Chippendale Residents Interest Group

Central Park: Response to Proponent's RTS Report: Concept Plan (mod 9) and SSD 6092 for Block 8

Annexure A: Response to Proponent's RTS Report Central Park, Changes to Concept Plan (mod 9) & SSD 6092 for Block 8

TYPICAL STREET FENCING &  
LANDSCAPE TREATMENT

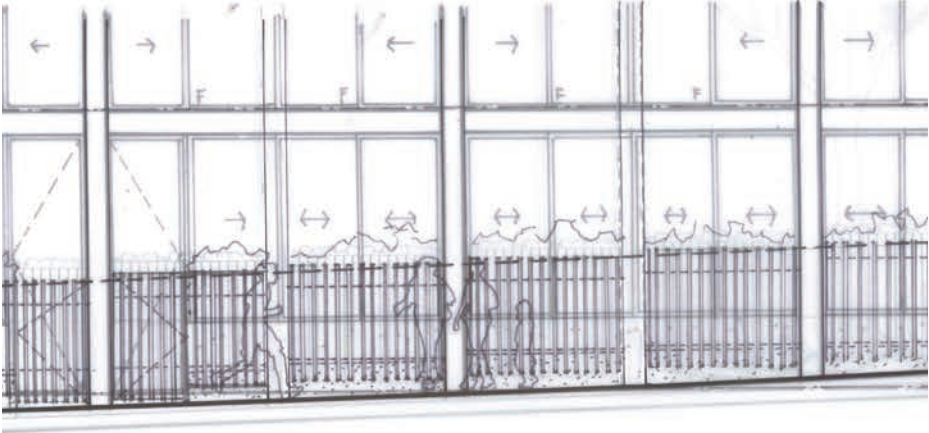
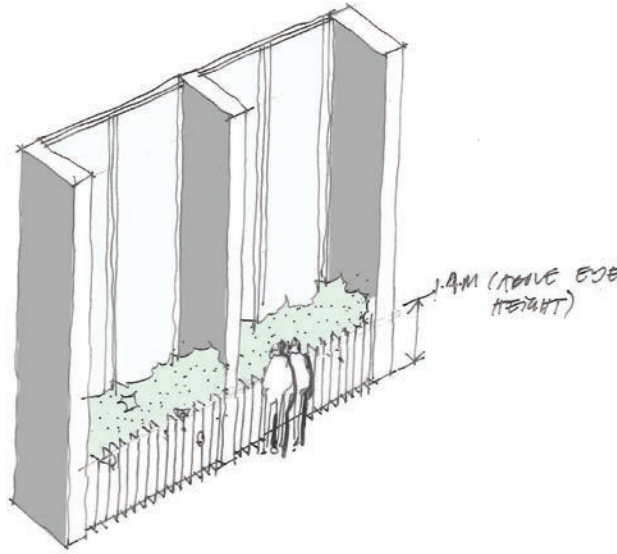
<ul style="list-style-type: none"> • The inclusion of the fence at the ground level is unattractive and not in keeping with the local area or Central Park (it does not provide a seamless integration rather meets crime concerns rather than rethinking the design) • 60% of the units are not naturally cross ventilated • 25% of the kitchens do not have natural ventilation • The apartment mix does not meet local planning guidelines • Solar access guidelines are not meet • Acoustic privacy guidelines are not meet for a number of apartments • The internal depth of apartments is not meet for a number of apartments • Setback between block 8 and properties on O'Connor Street (being 24 metres) is not met • The building presents as a "wall" along O'Connor Street
Development near rail corridors and busy roads (interim guidelines)	In accordance with the guidelines, acoustic treatments will be needed to meet the relevant standards. This will necessitate the closure of windows/balcony doors. However this will have a direct relationship on cross-ventilation thereby not meeting the relevant environmental standards.
